M/132/21/HH

South Walk Middleton-On-Sea PO22 7RW

Erection of part single, part two storey side extension and single storey other side extension following the demolition of sunroom and conservatory

## PROPOSED ELEVATIONS OF

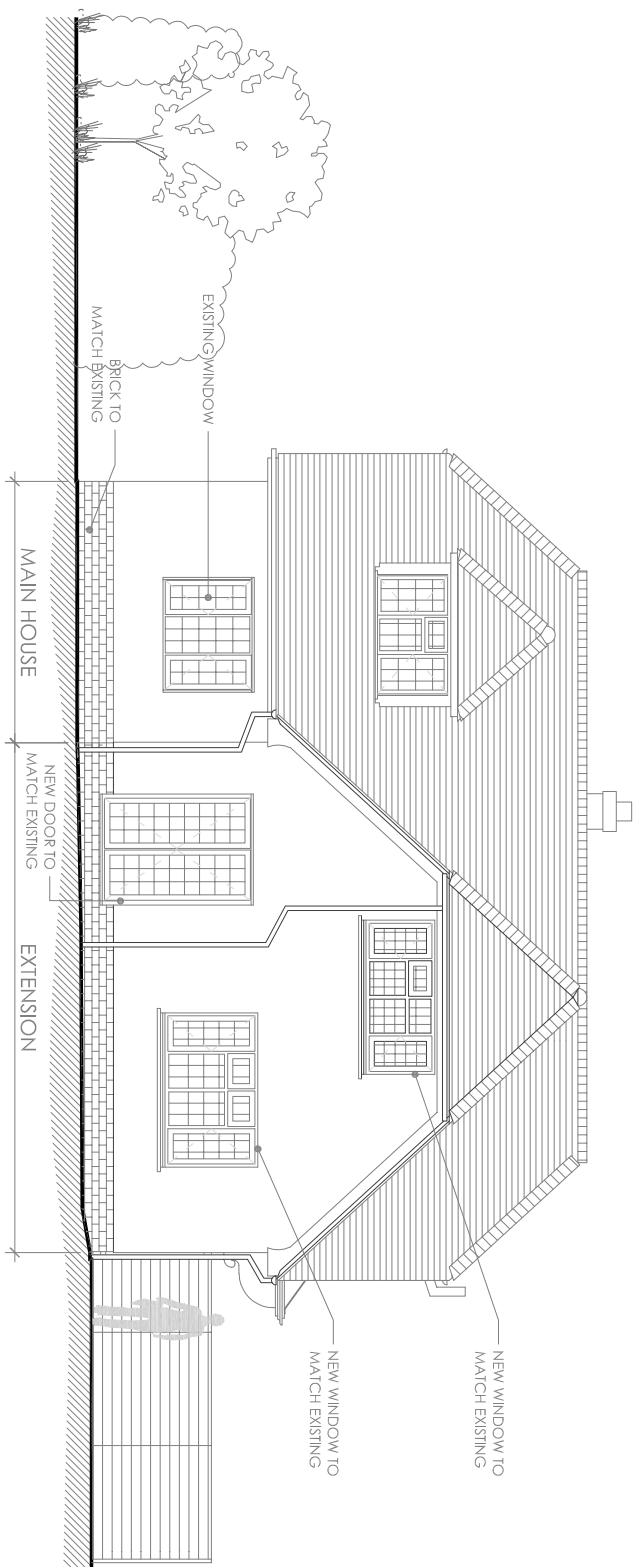
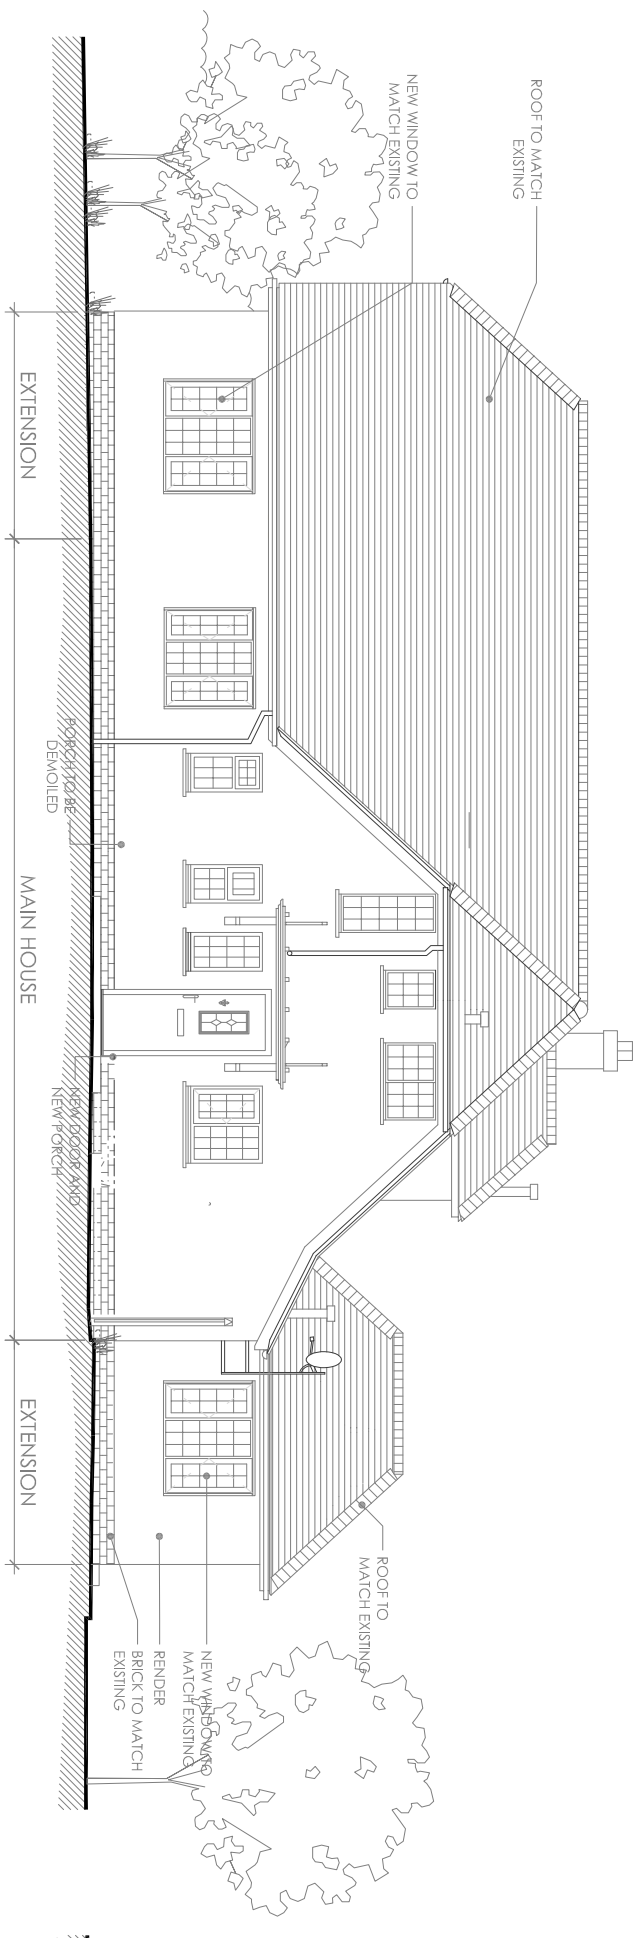
The proposal appears to relate to a front extension and a separate one to the rear, both of which appear to reflect the character and appearance of the host dwelling. Whilst the front extension will bring the front elevation forward, closer to the road, it would still generally reflect the building line on this part of the road and therefore not be out of character. The use of materials to match the existing is also a positive feature of the design. Therefore, overall, I am of the opinion that the development will not cause harm to either the building or the area of character.
